Application No: AB/44/21/HH
Site Address: Fern Cottage 5A Surrey Street Arundel BN18 9DT
Description of works: Proposed loft conversion (This application may affect the setting of the Arundel Conservation Area).

Thank you for your internet representation made on 16th May 2021 which has been recorded as an objection with the comments as follows:

Proposed Loft Conversion Plans and Elevations Planning
Date March 2021
Scale 1:50

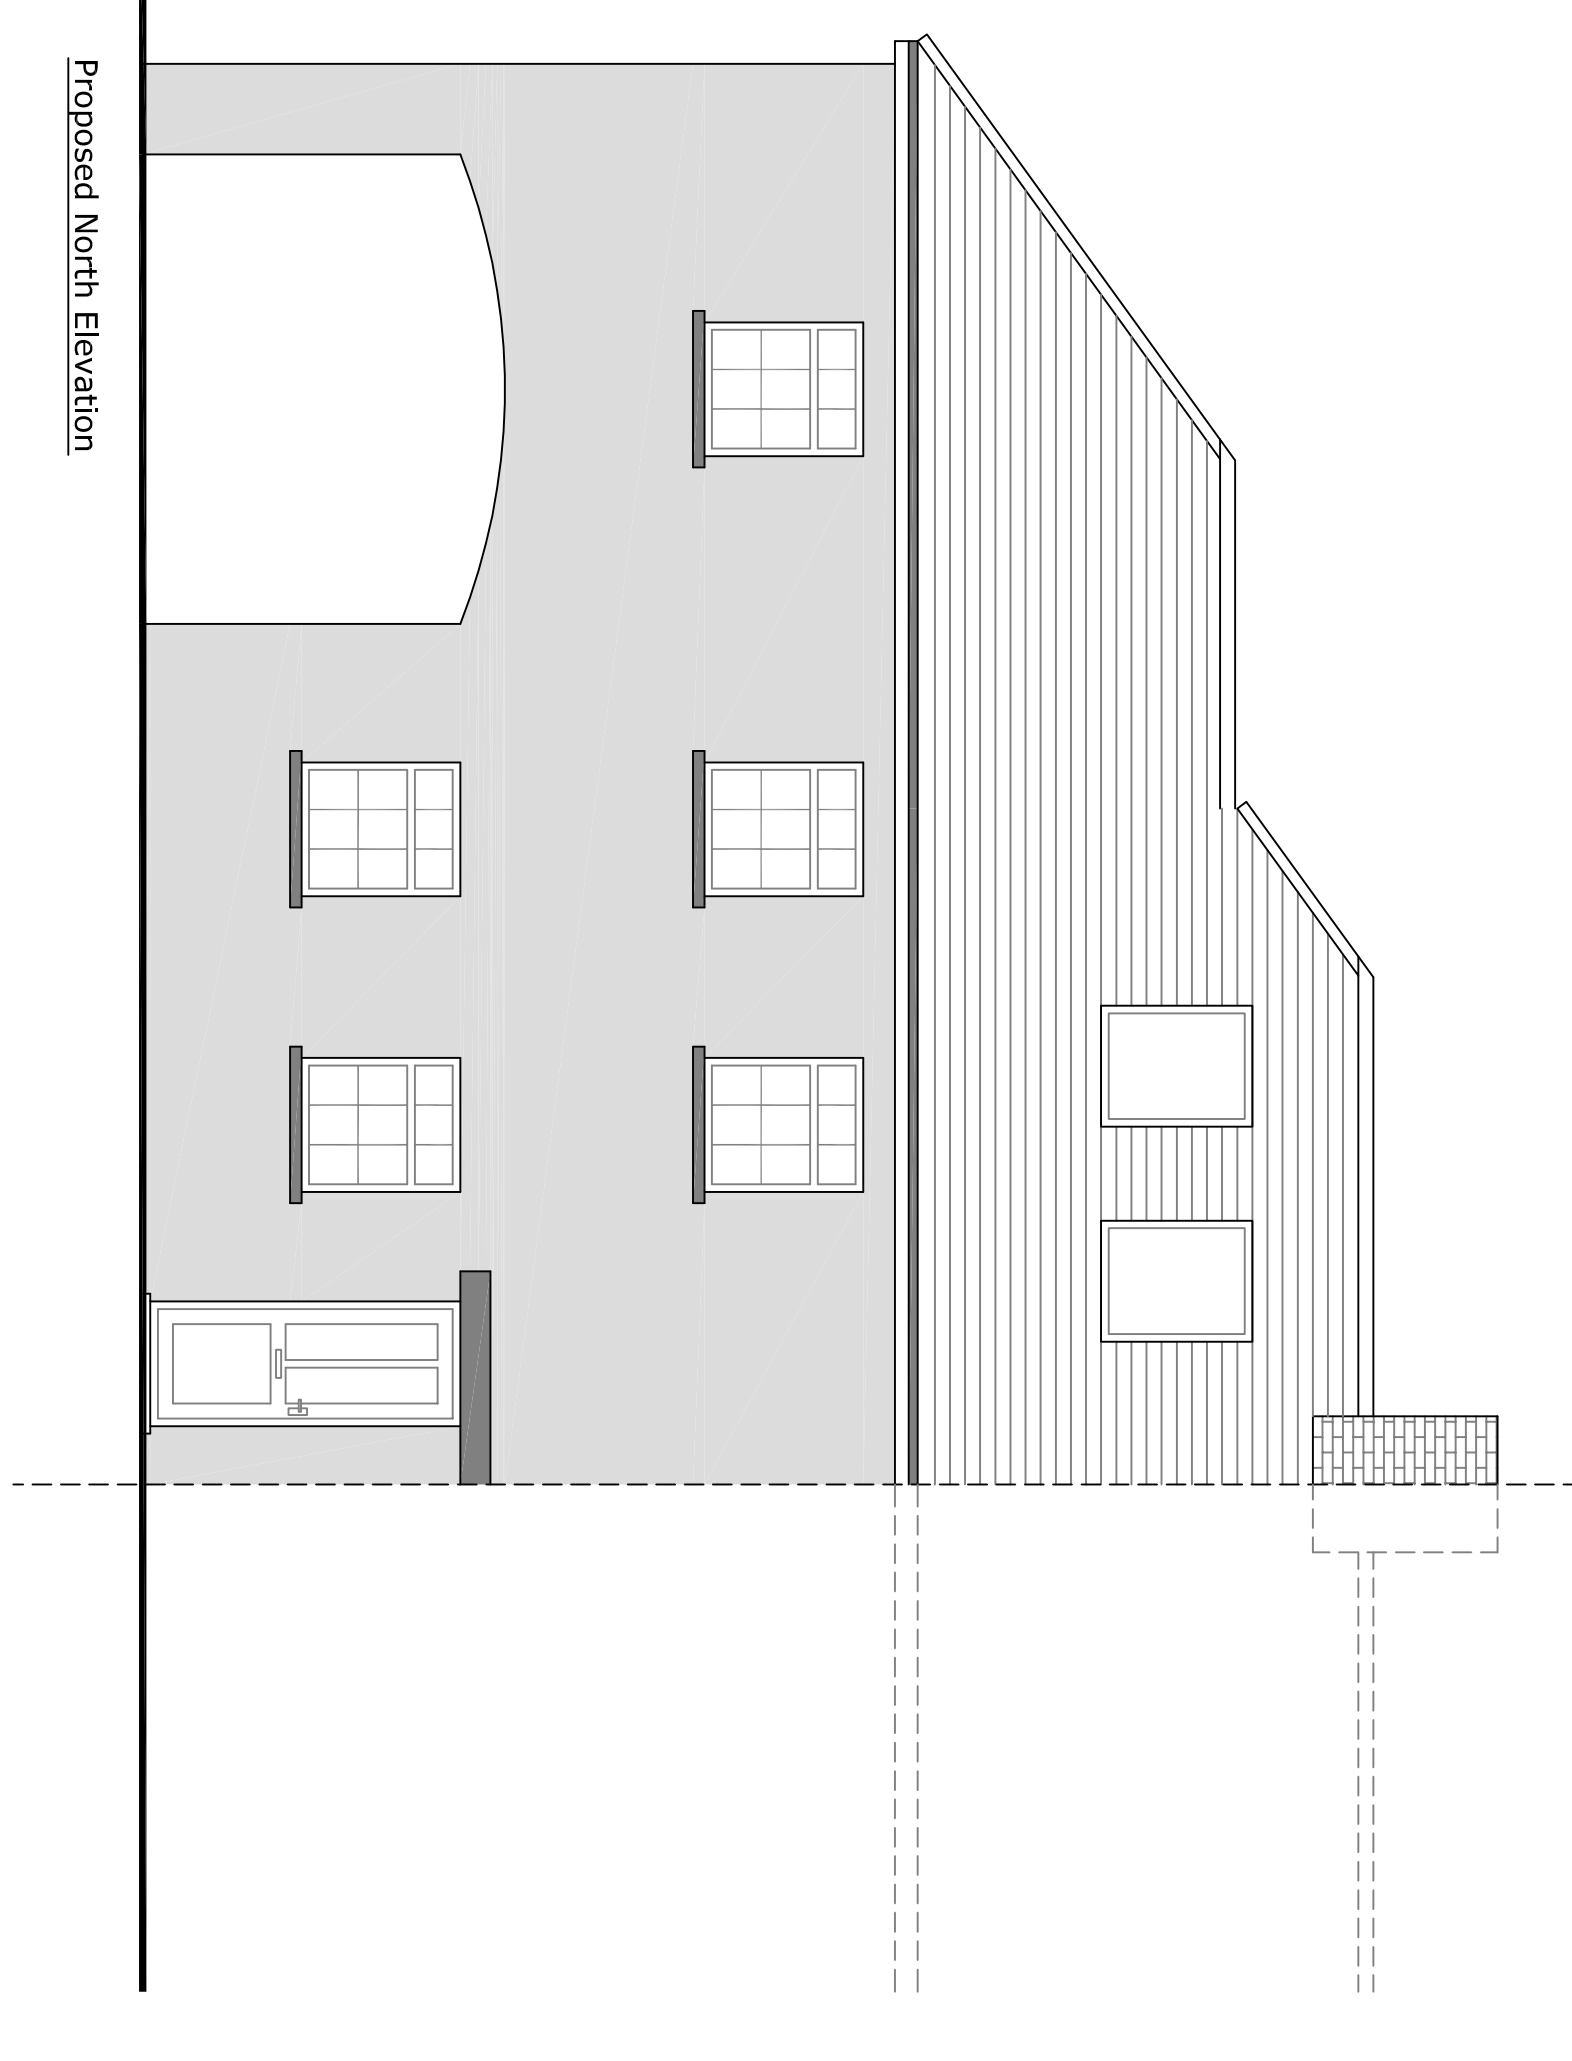
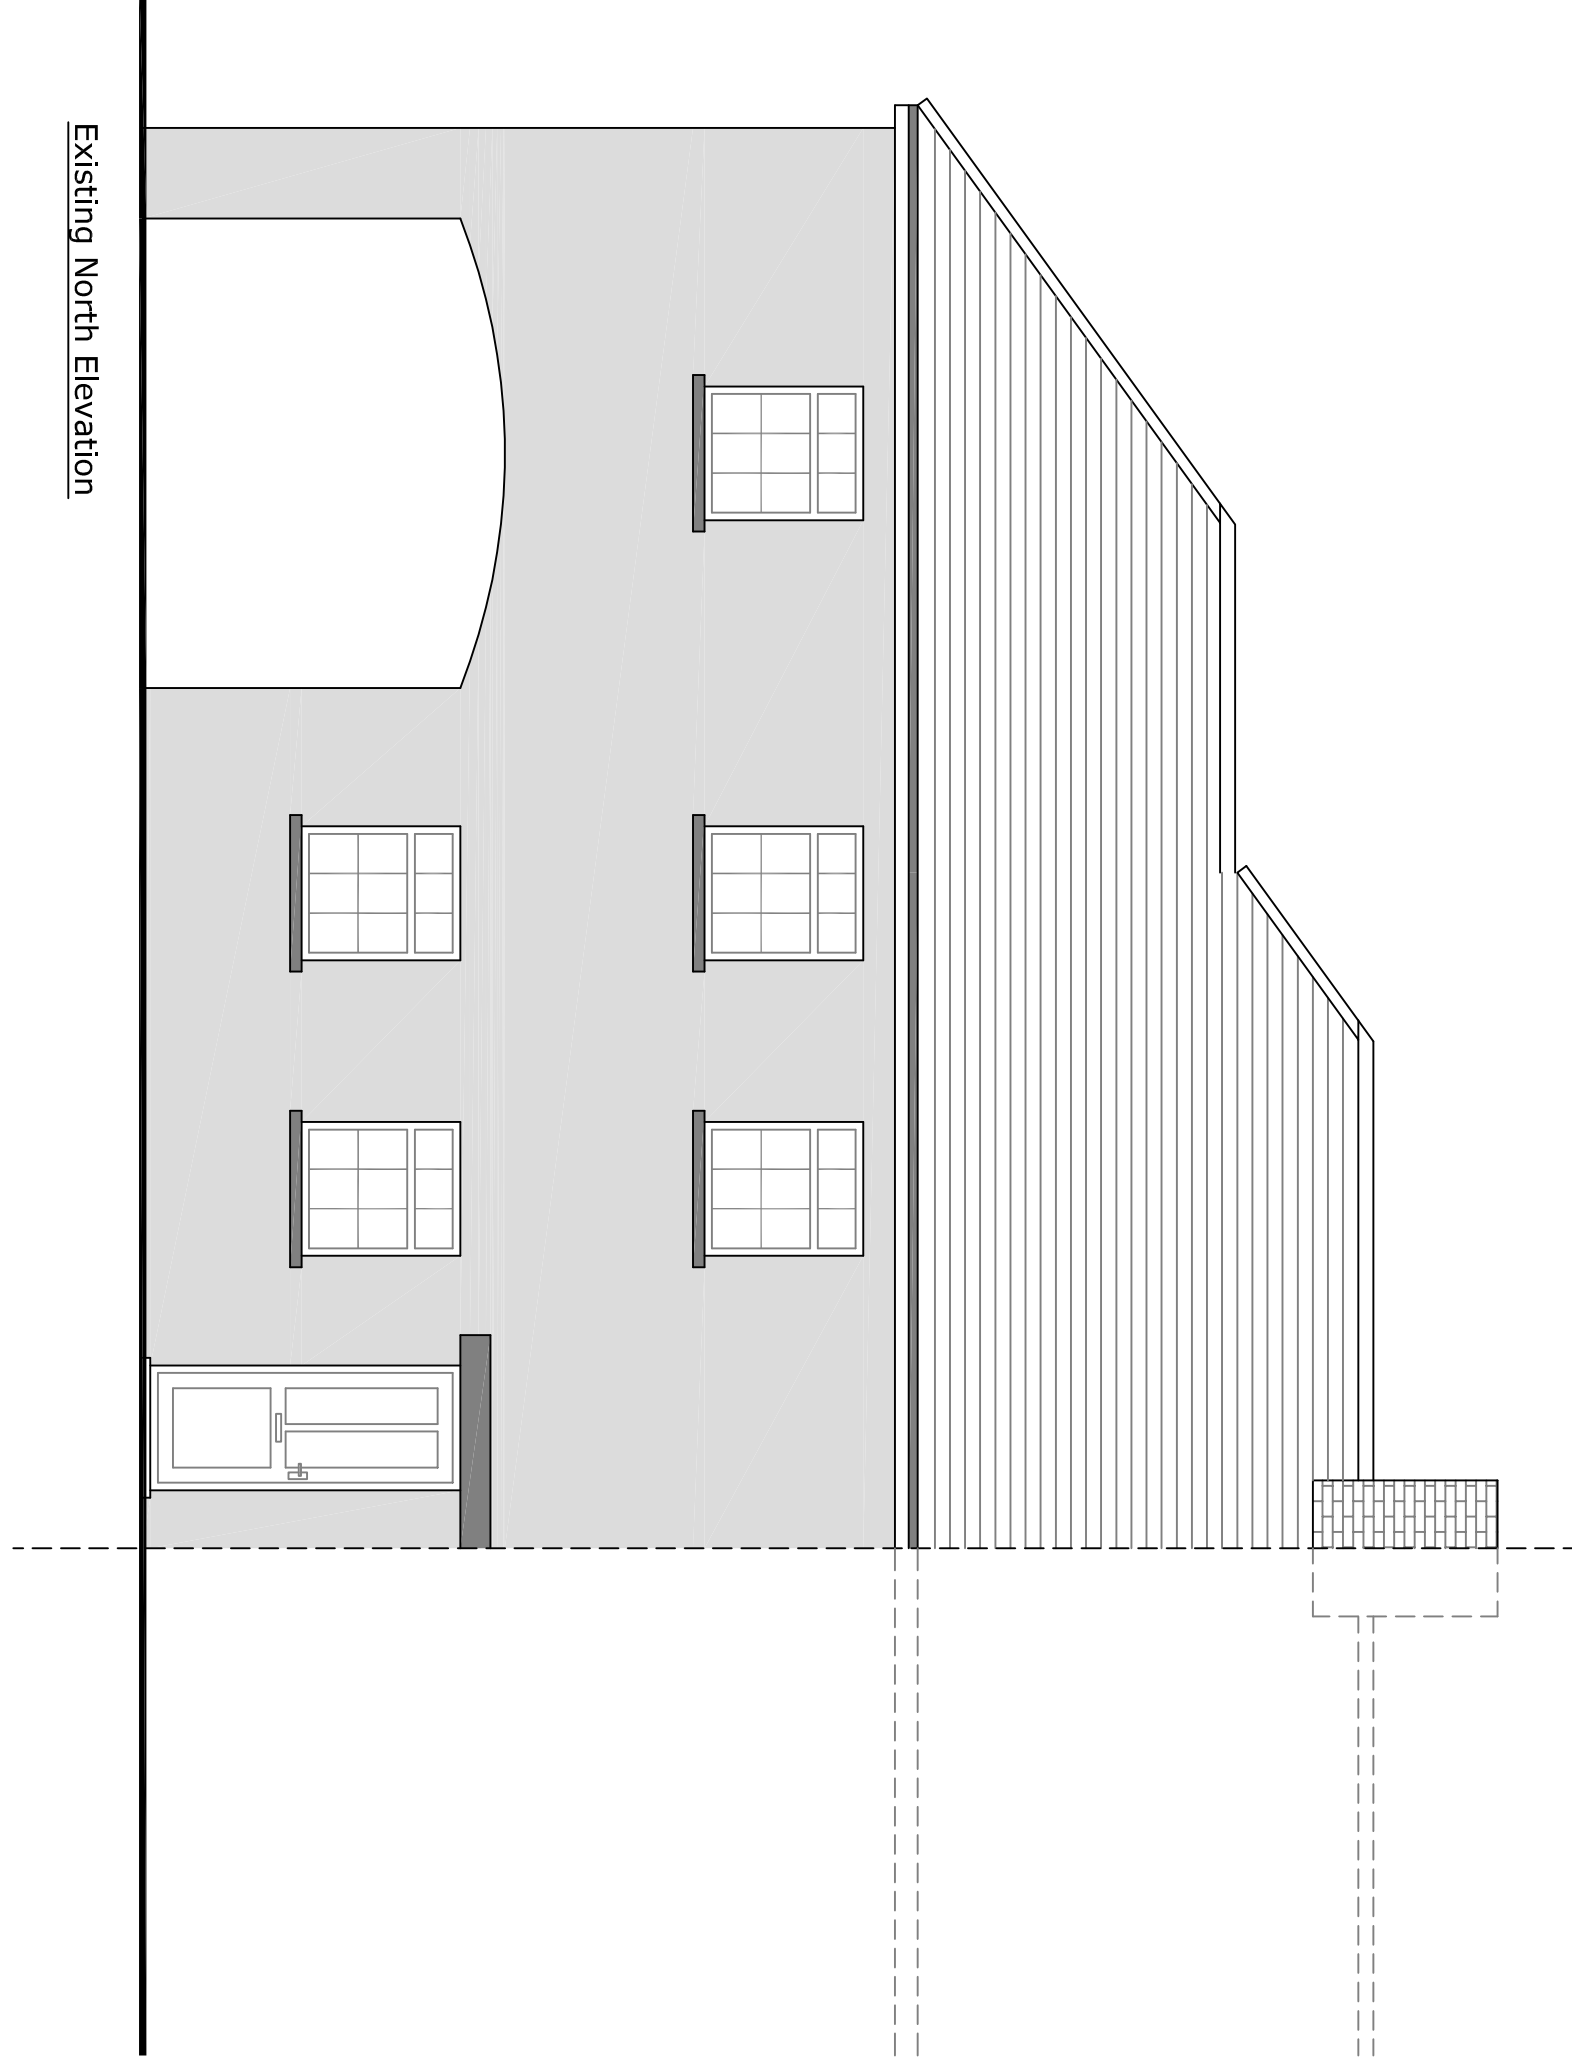
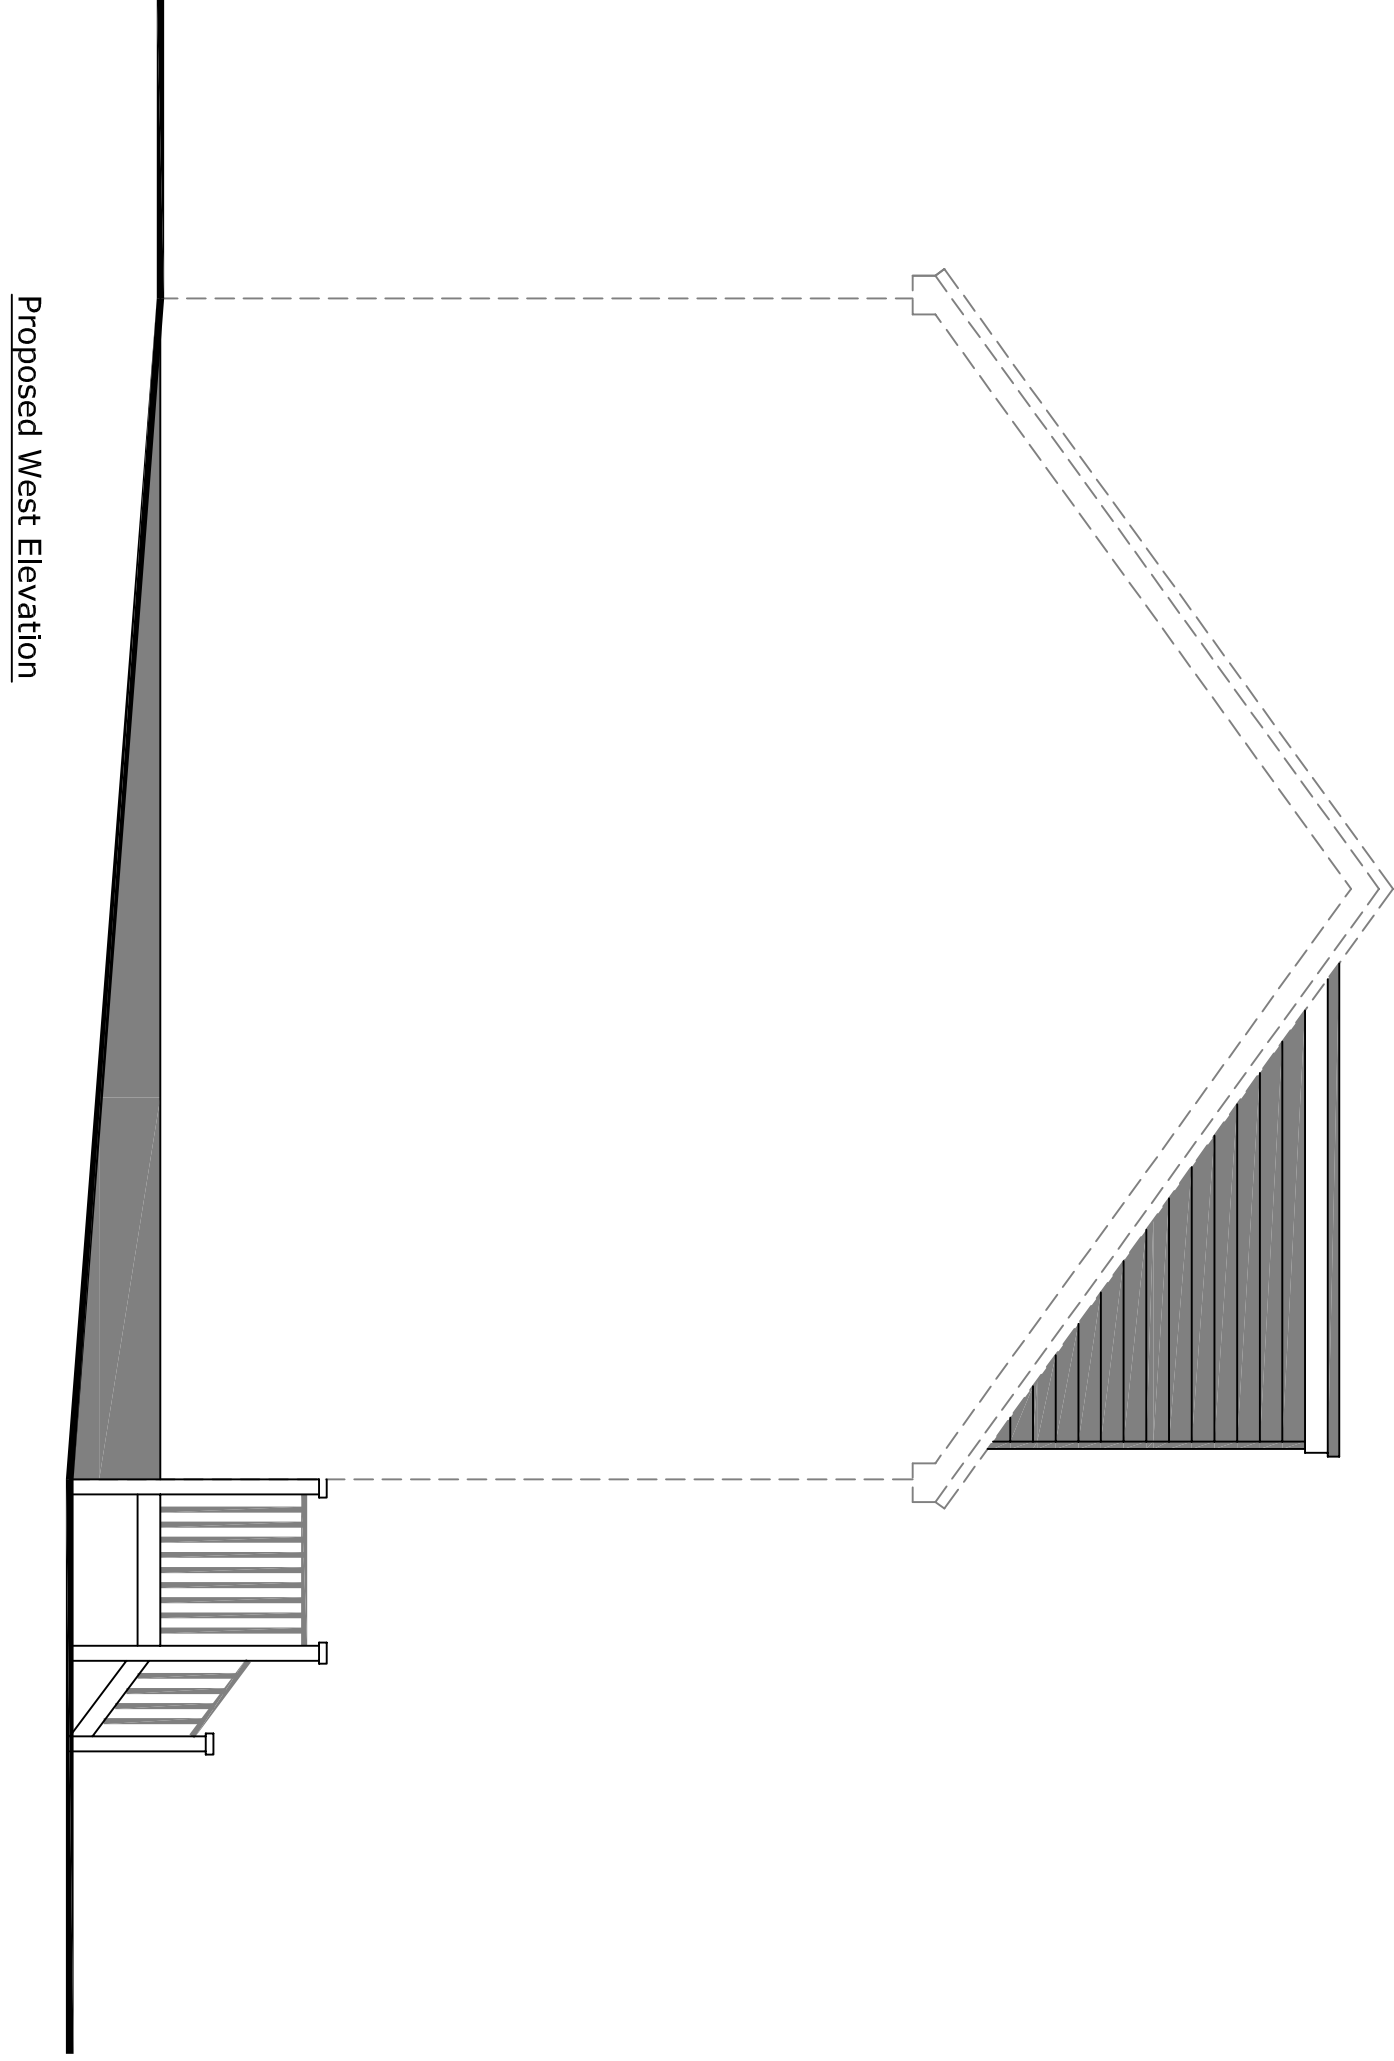
On the rear elevation a very large dormer extension is proposed which will largely not be seen from Surrey Street or The Slupe. It does, however, necessitate a change in the shape of the main roof at its eastern end which will appear incongruous when viewed from Surrey Street and School Lane.

Very large rooflights are proposed for the front elevation which will detract from the appearance of the building, the street scene, and the setting of the listed group mentioned above and other and nearby listed buildings.

The plain, unaltered, continuous, front roof slopes of 5a -25 Surrey Street are attractive features in the Surrey Street townscape but if the Council considers that it could not refuse the principle of rooflights on the street elevation of the building then they need to be smaller and of conservation style and incorporating central vertical glazing bars.
